<b>Consultation Response from: KC Environmental Health (Pollution &amp; Noise Control)</b>		
<b>2020/92351 Batley Police Station, Market Square, Batley, WF17 5AA</b>		
<b>Change of use of former police station to 9 apartments with associated works (Within a Conservation Area)</b>		
<b>Date Responded: 26 October 2020</b>	<b>Responding Officer: Mohammed Nasim</b>	<b>Responding Ref: WK/202021984</b>
<p><b><u>Comments</u></b></p> <p>In our original consultation response dated 7 Sep 2020, we recommended a condition requiring a noise impact assessment with details of necessary noise mitigation measures. The applicant has now submitted a noise impact assessment authored by Acoustic Solutions dated 10 October 2020 Ref 1965-76-20. The findings of the assessment show the Western façade of the building to be exposed to noise levels exceeding those within BS8233 and this is shown in table 5.2 for daytime and evening levels and table 5.3 for nighttime levels.</p> <p>Para 6.1 of the assessment recommends mechanical ventilation and whilst a noise level of 23dB is quoted at 3m, the Technical Information on the Titon website for this product - <a href="https://www.titon.com/uk/products/ventilation-

Drawing:
PROPOSED FLOOR PLANS

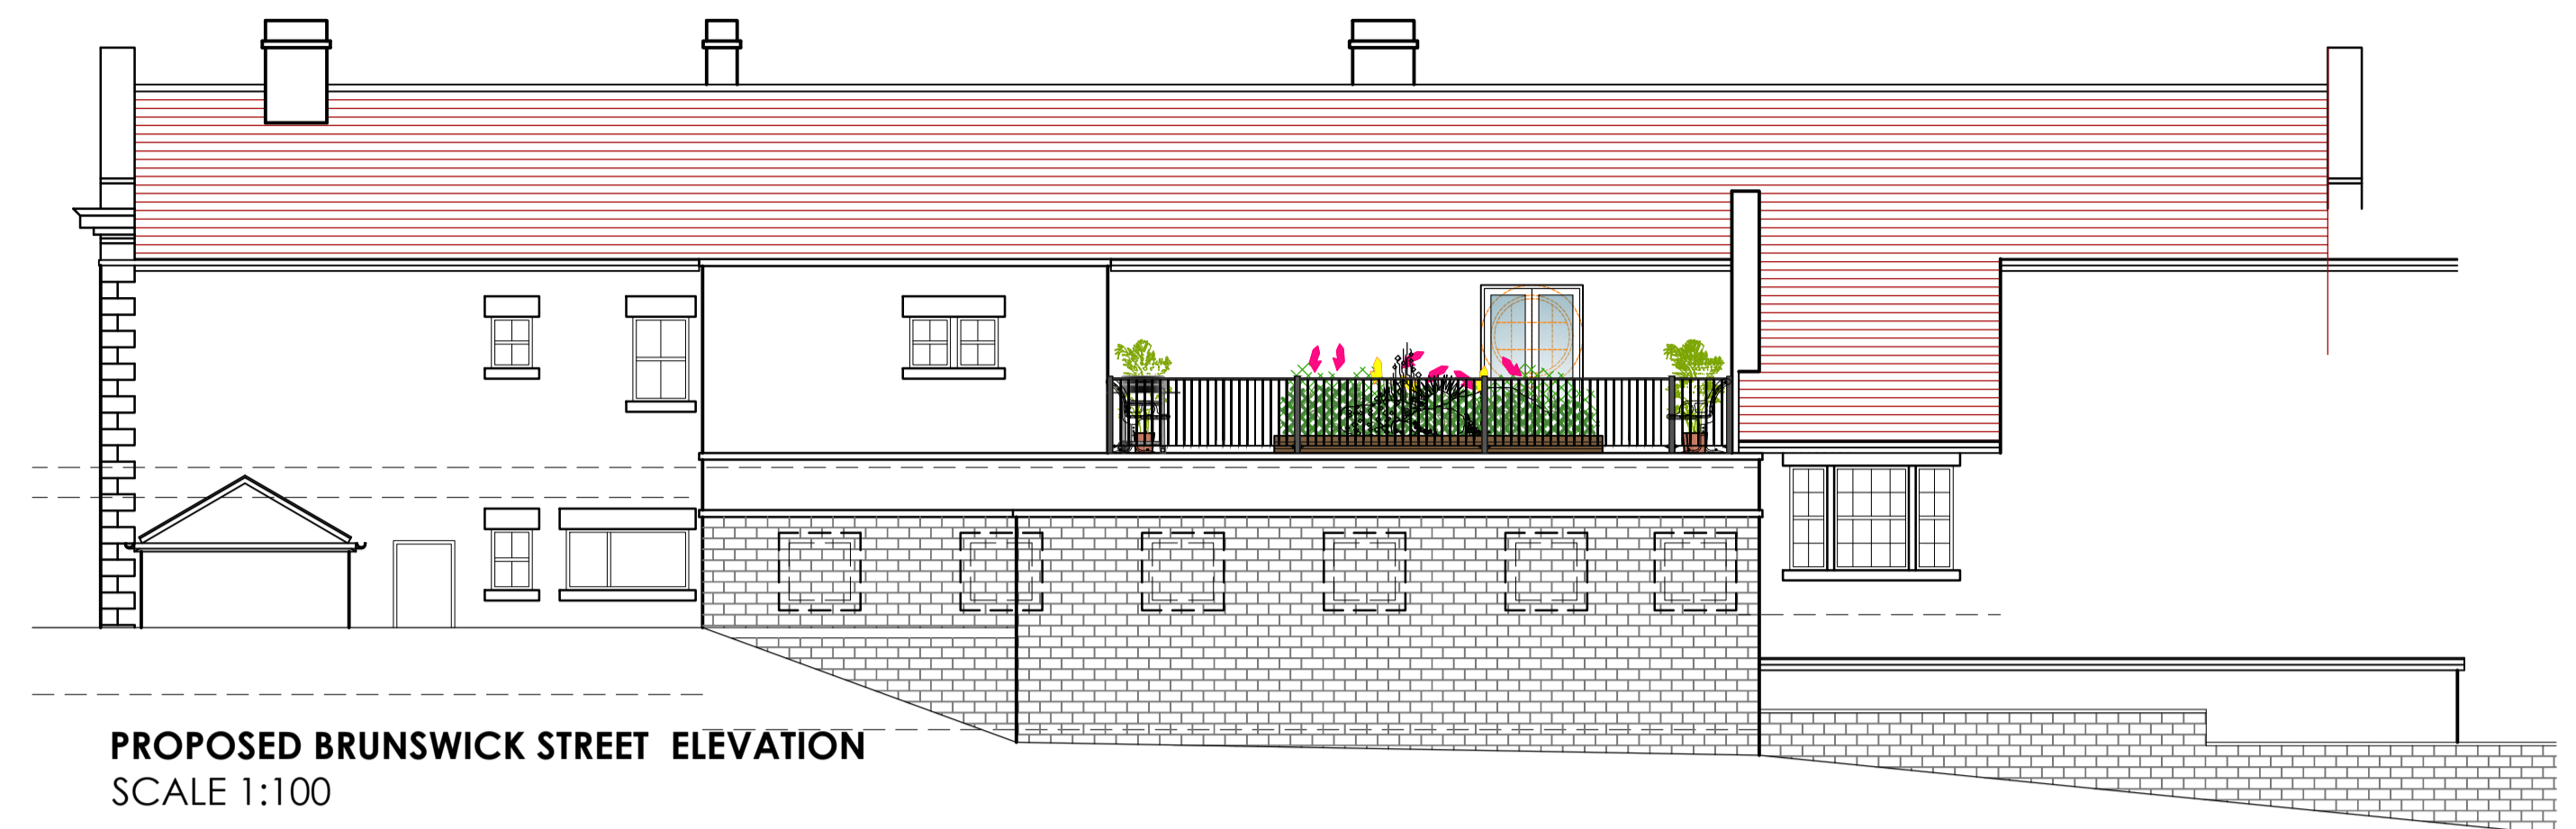
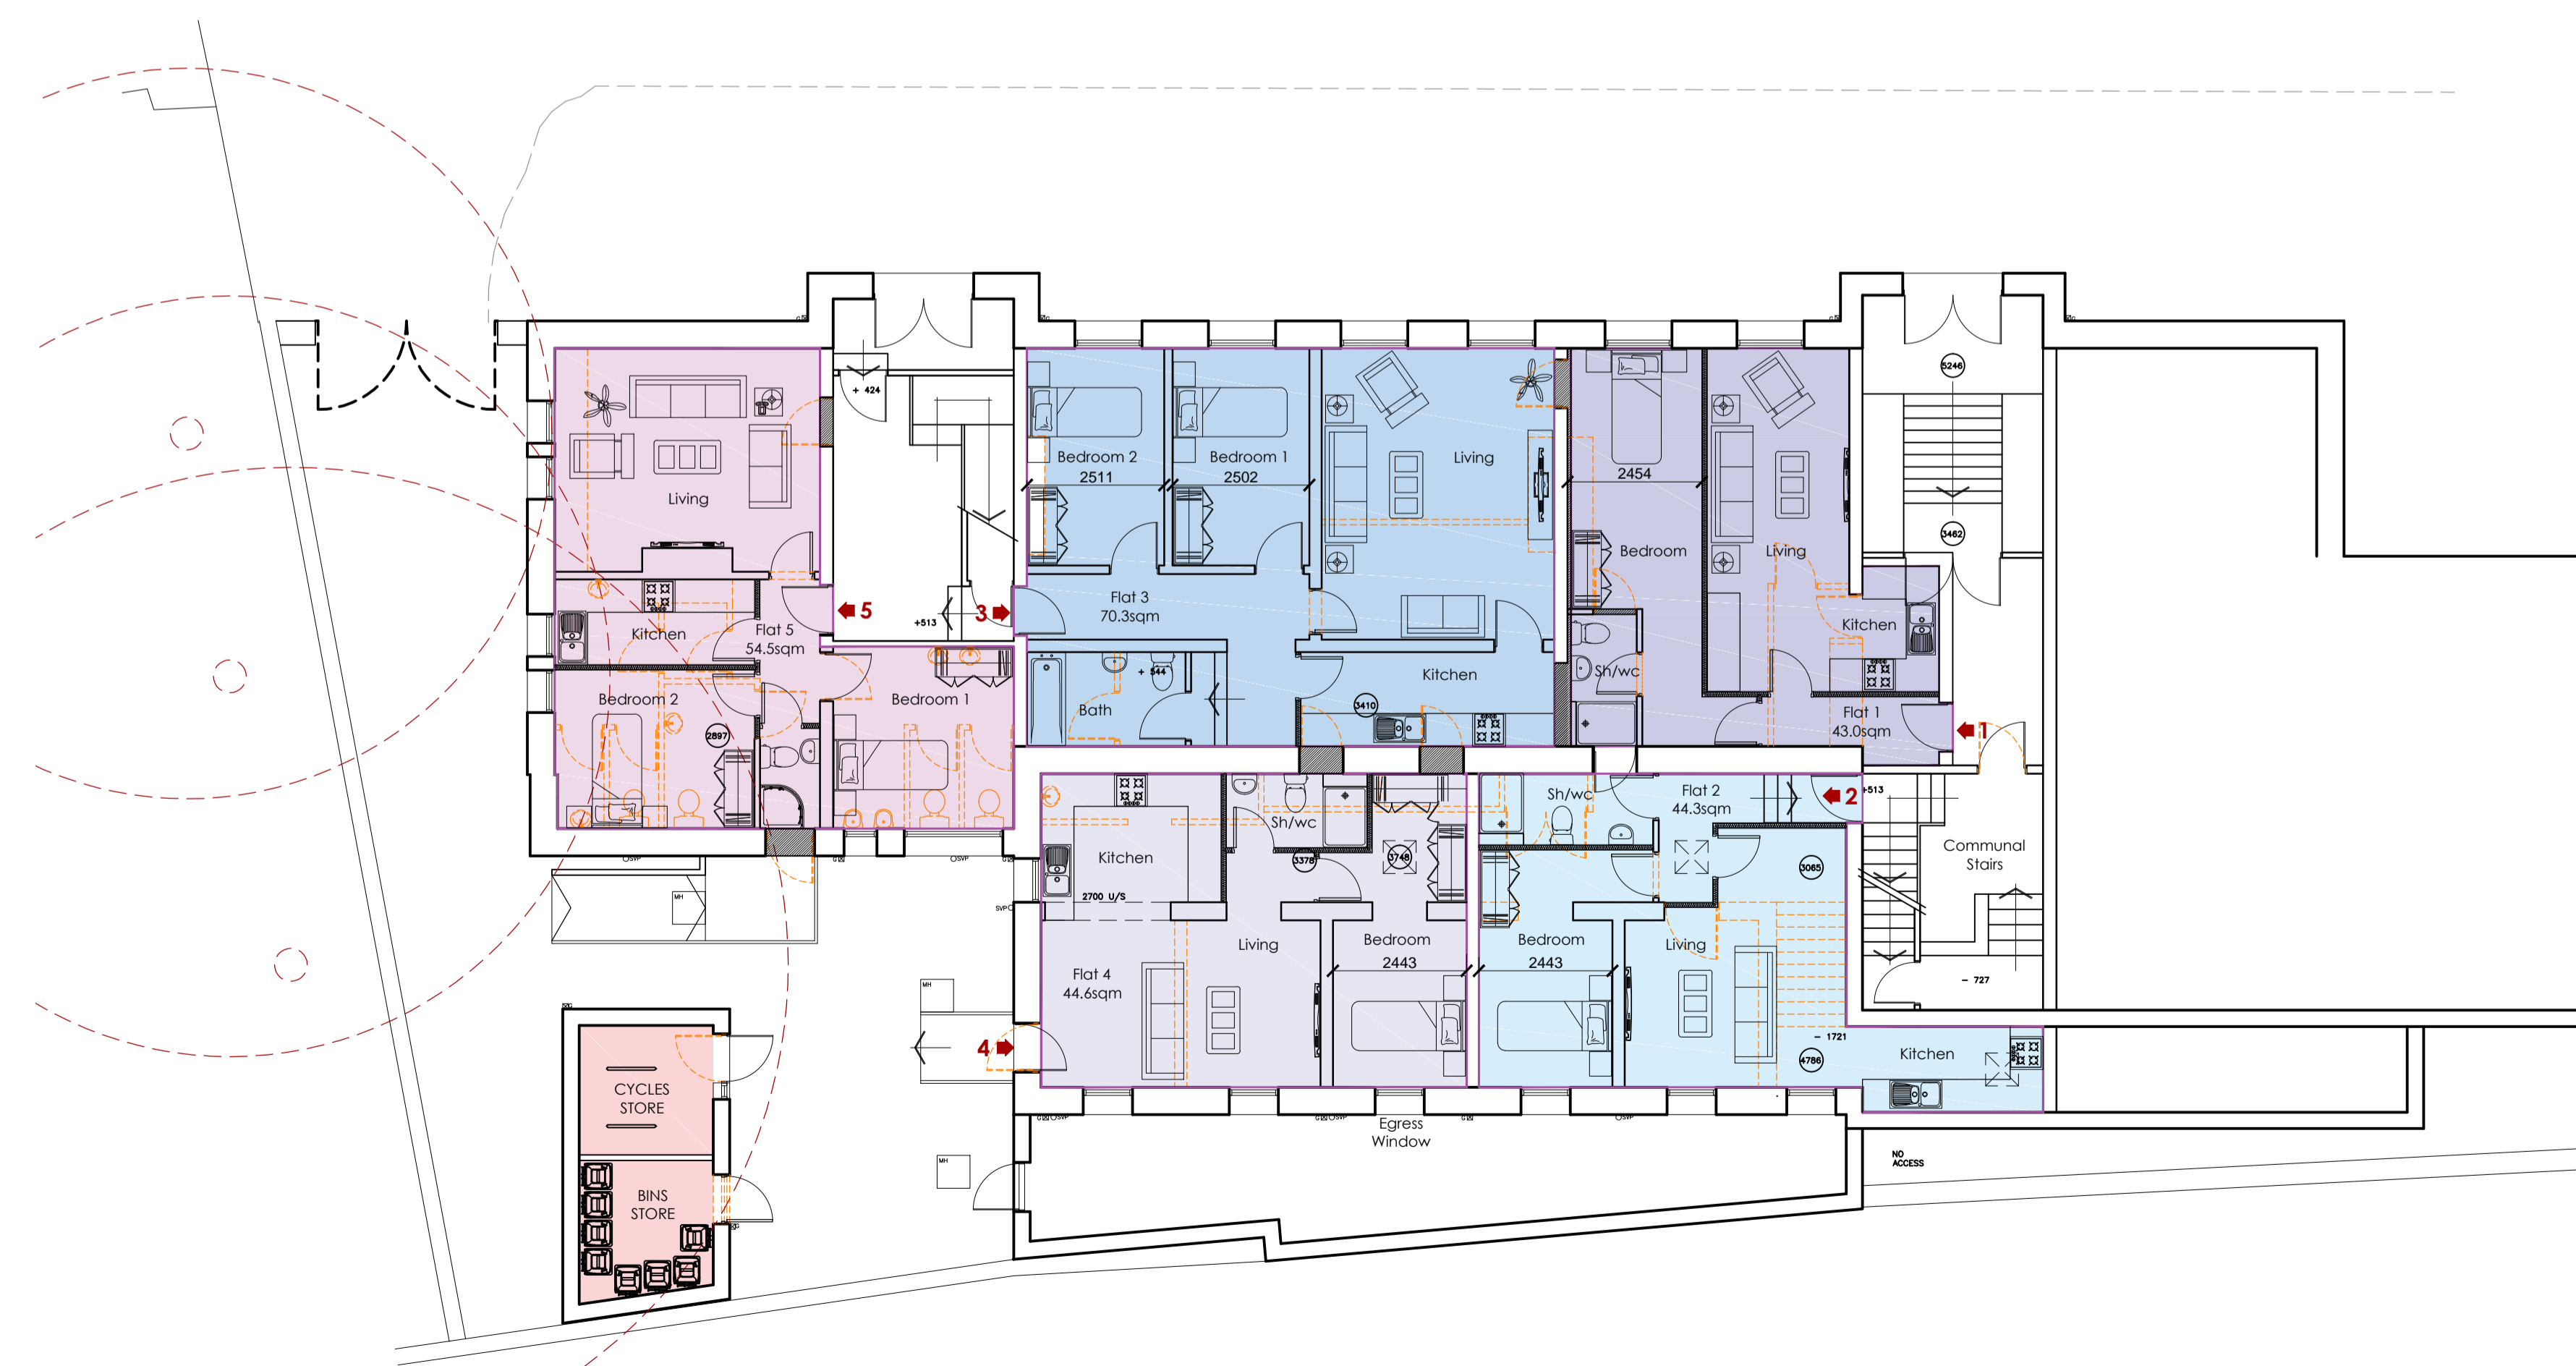
Because windows need to be kept closed to prevent excessive noise levels, before any construction work commences, a ventilation scheme shall be submitted to and approved in writing by the Local Planning Authority. The ventilation Scheme shall show how habitable rooms of these apartments shall be provided with sufficient ventilation to help control thermal comfort and avoid over heating during hot weather without the need to open windows. All works which form part of the approved scheme shall be completed prior to occupation of the aforementioned apartments and retained thereafter.

A ventilation scheme that meets the performance specification given in Part 6 of Schedule 1 of the Noise Insulation Regulations 1975 is likely to be acceptable. Trickle ventilation alone is unlikely to provide sufficient ventilation to help control thermal comfort without the need to open windows and would therefore not be acceptable.
